# Wylfa Newydd Project

Horizon's Responses to ExA's Questions  
from the February 2019 Accompanied Site  
Visit

PINS Reference Number: EN010007

22 February 2019

Drawing Number WN0902-HZDCO-LFM-DRG-00023 Rev 1.0

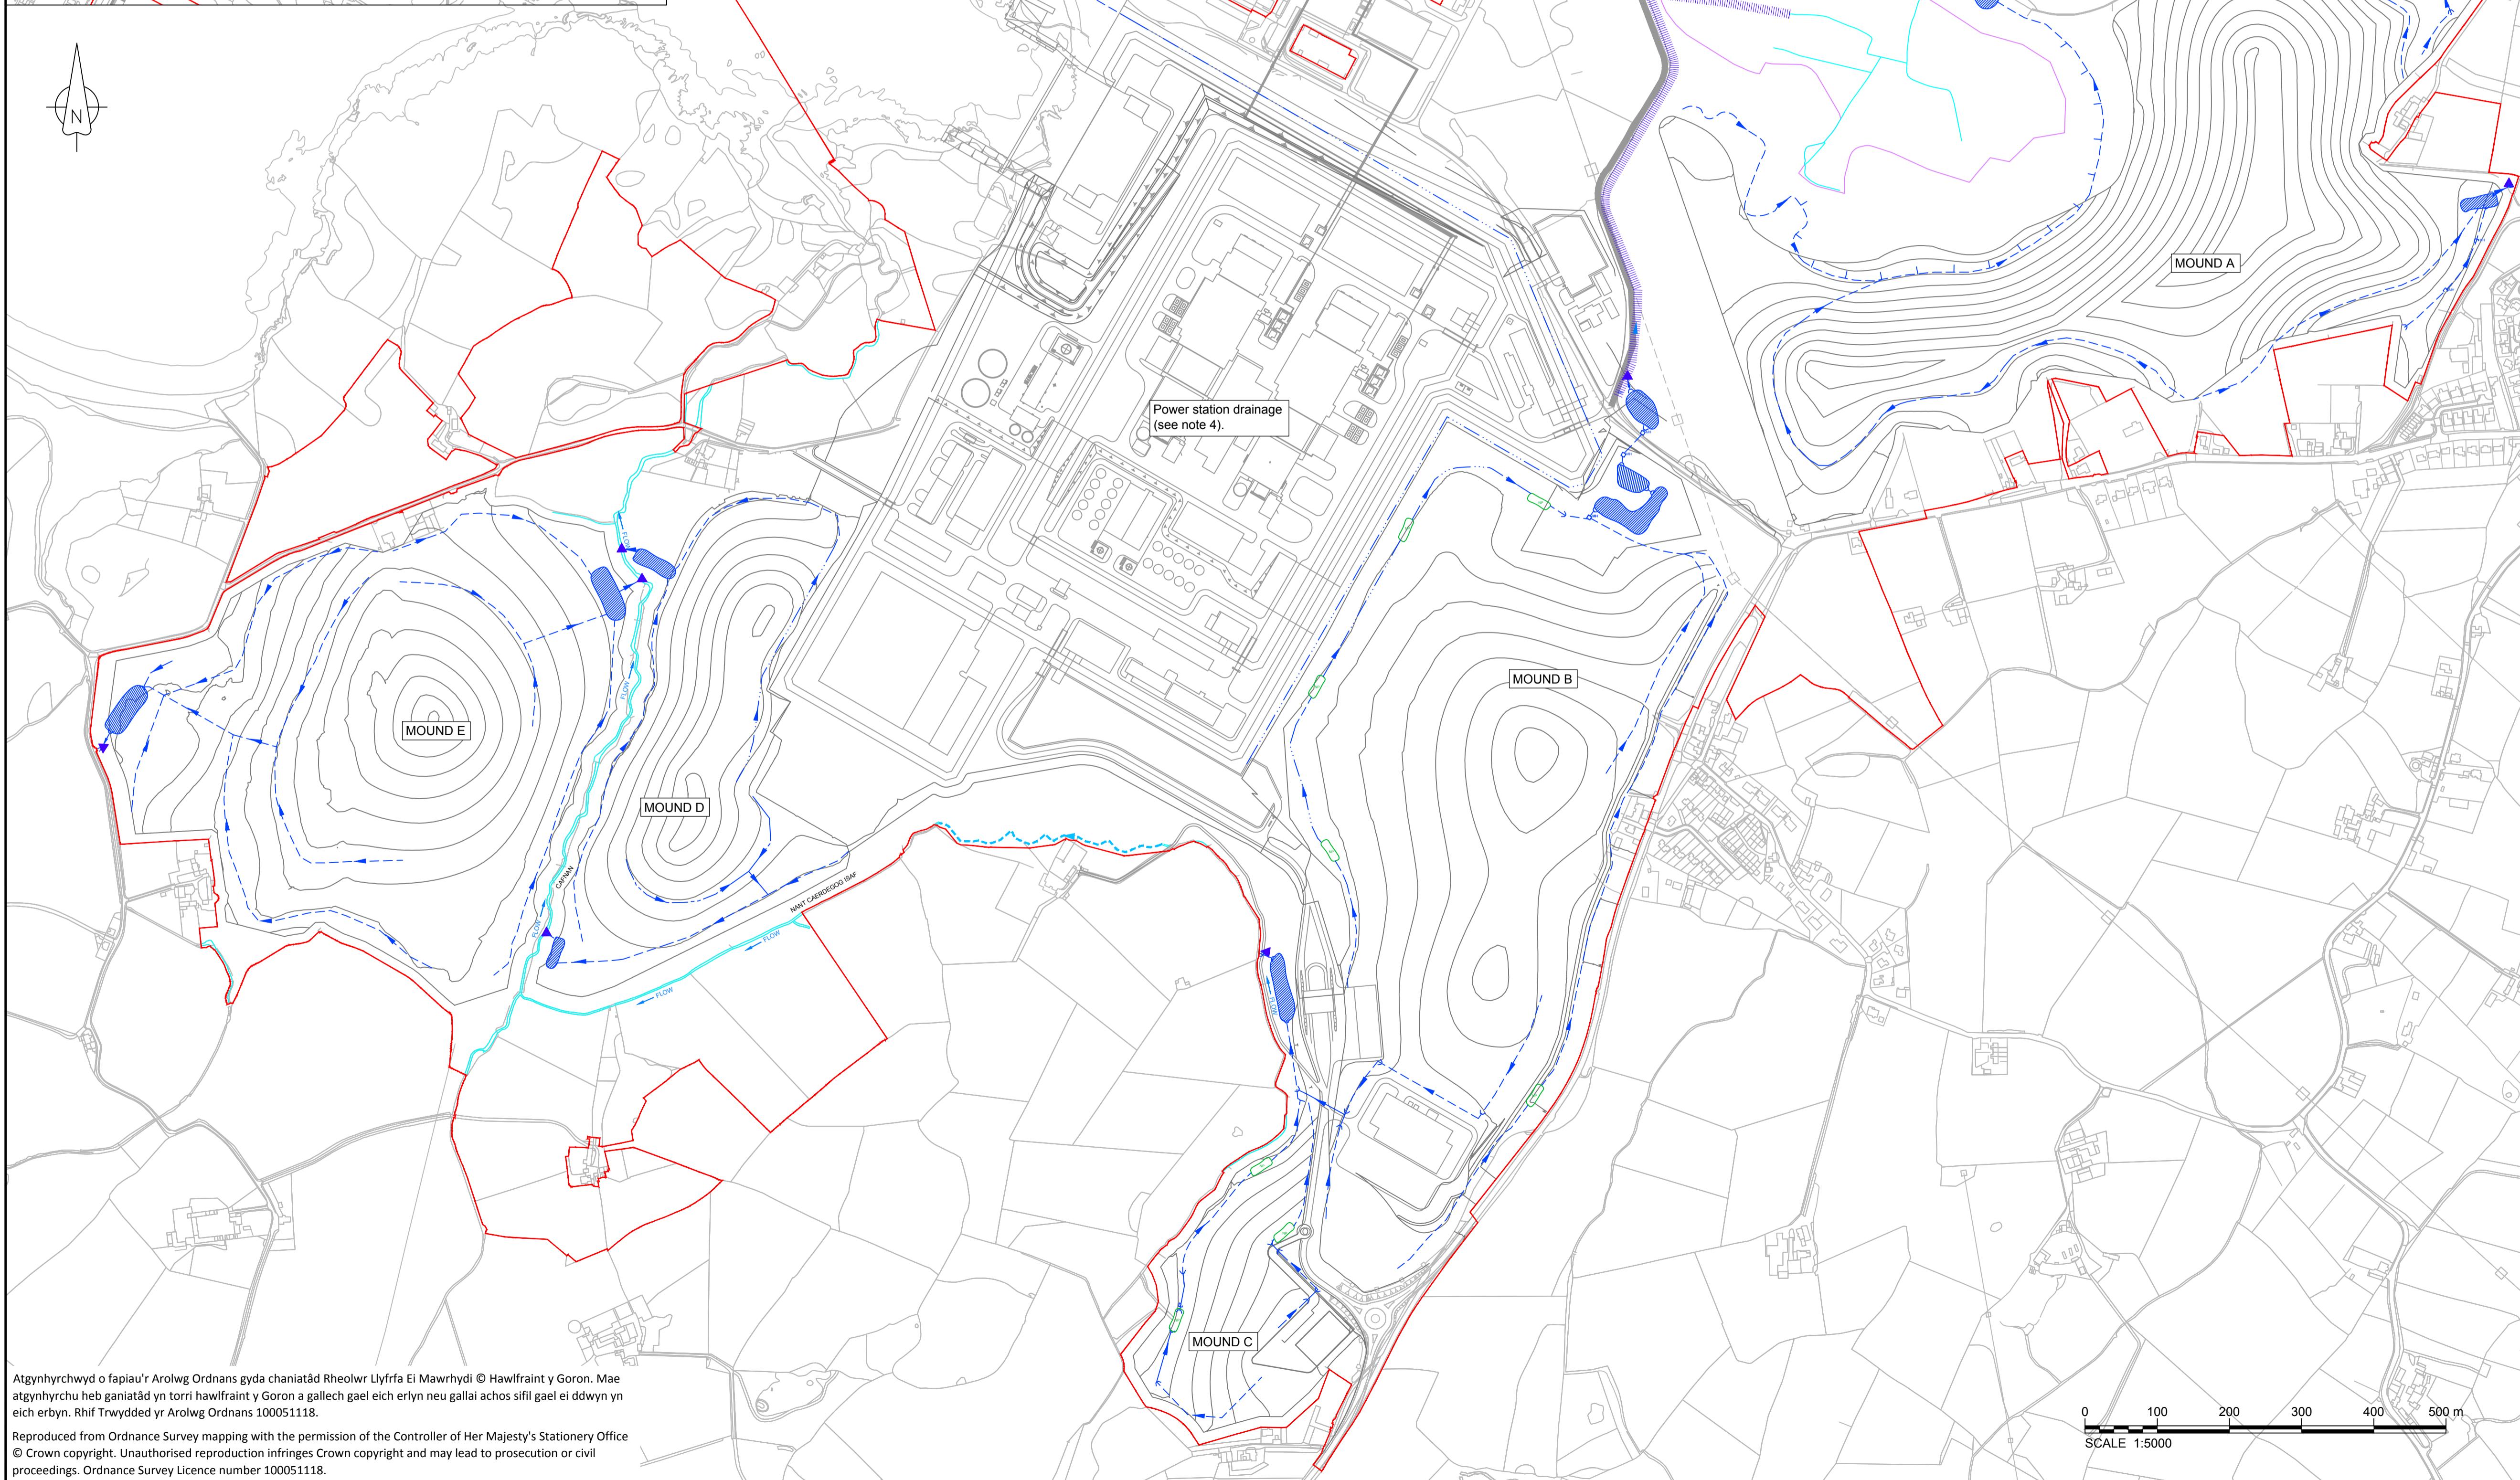
<p>ASI.Q9</p>	<p>Will Horizon have flexibility to retain siltbusters on Mound E?</p>	<p>Silt management dosing plants are shown adjacent to the Mound E sedimentation pond in drawing WN0902-HZDCO-LFM-DRG-00023 in the site plans for construction drainage [REP2-018], and Figure 2-8 of ES Volume D - WND A Development App D8-8 - Summary of preliminary design for construction surface water drainage [APP-167]). These drawings are labelled as 'illustrative' and locations of dosing plants as 'indicative'.</p> <p>Assuming that the diversion of water from the west of Mound E into the Afon Cafnan (and the commitment to not dose the water being discharged into the Nant Cemlyn) are approved, it is likely that it will not be necessary to locate these particular dosing plants in the vicinity of the Nant Cemlyn. Further consideration of options will be undertaken at the detailed design stage regarding locating any required dosing plants in the vicinity of the discharge to the Afon Cafnan</p>

Scale	AS SHOWN	Sheet Size	A1	Sheet(s)	1 of 1
Drawing Number	WN0902-HZDCO-OHW-DRG-00063				Rev
				2.0

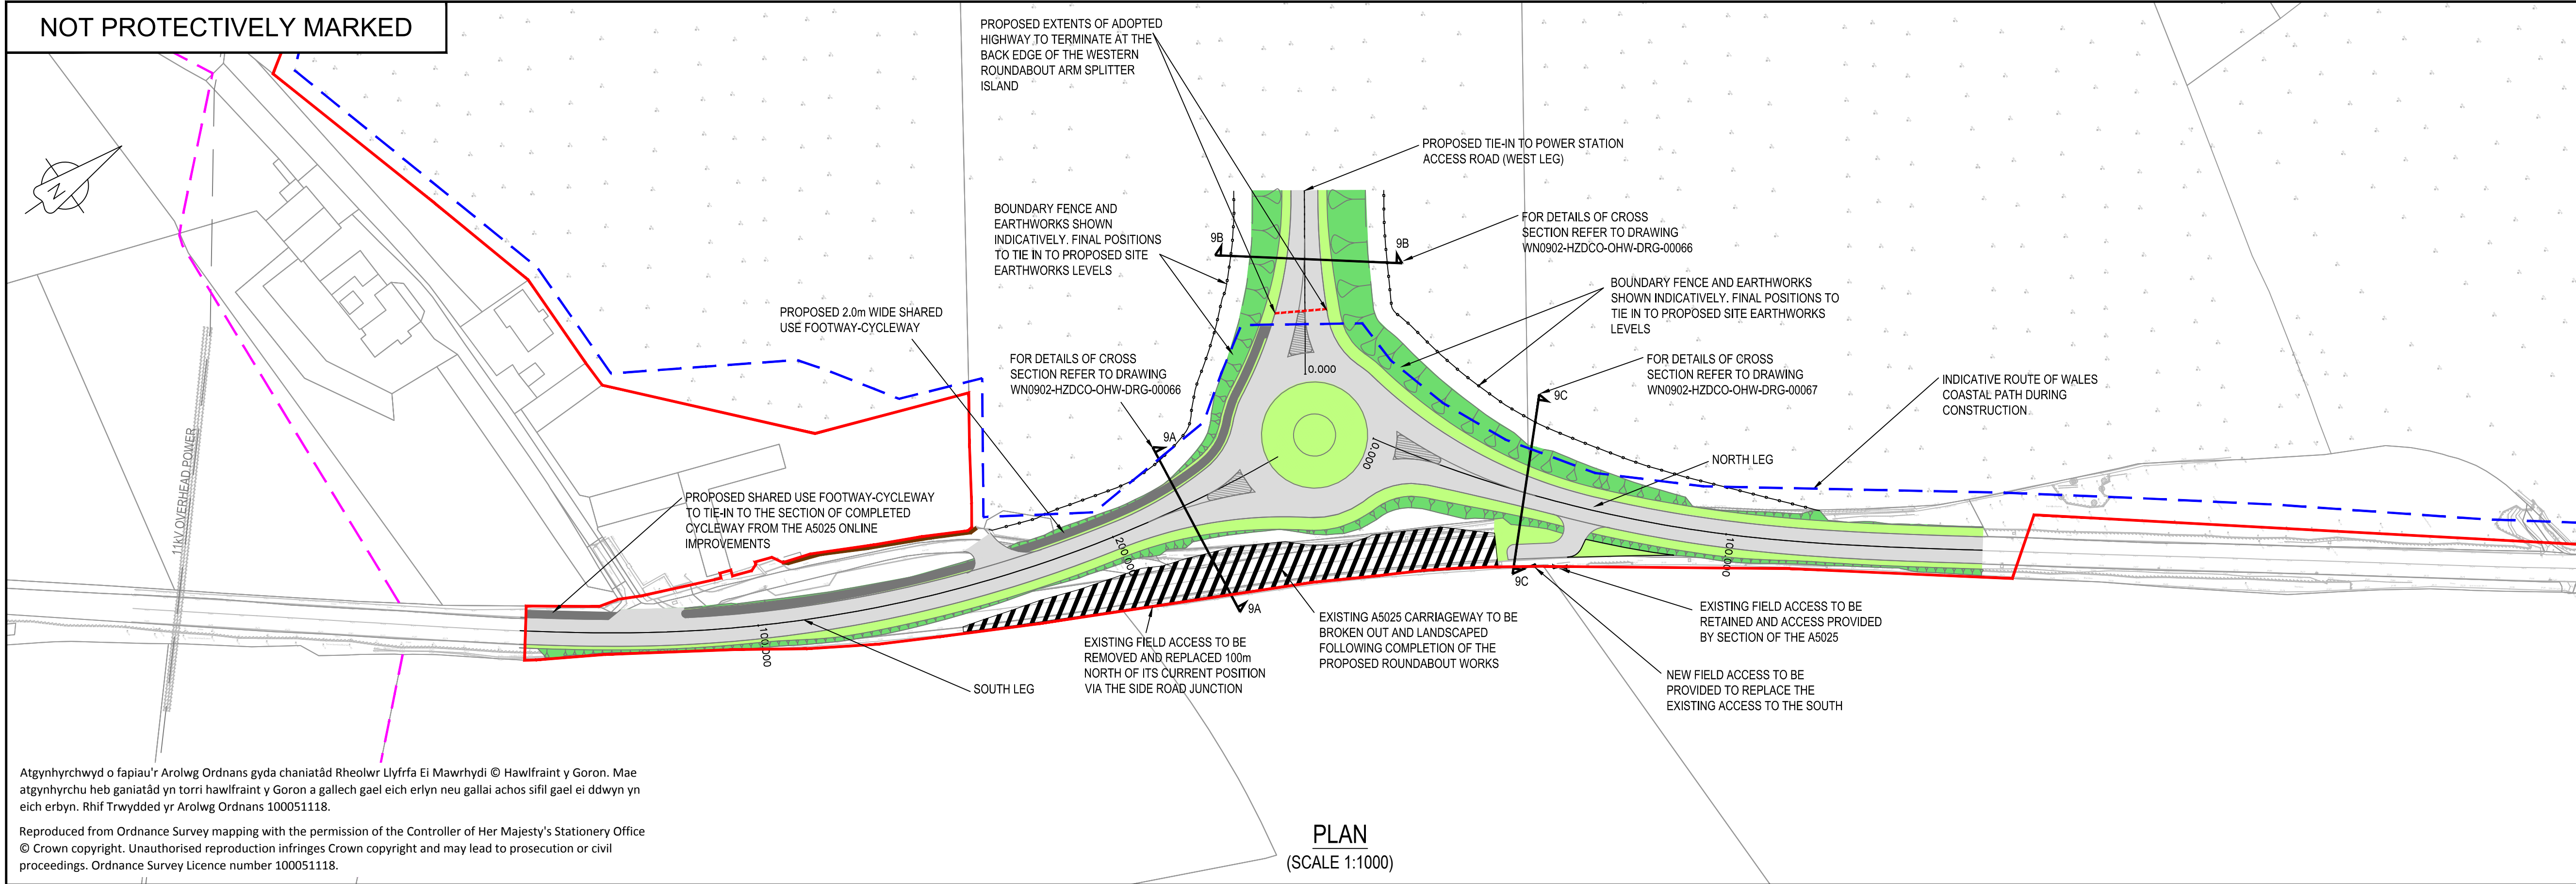
<p>ASI.Q13</p>	<p>Clarification is required on the Power Station access drawing to illustrate the construction of the footway/cycleway.</p>	<p>As shown in the general arrangement plan submitted for approval (WN0902-HZDCO-OHW-DRG-00063 in [REP5-014]), there is a cycle crossing on the site entrance arm of the junction.</p>
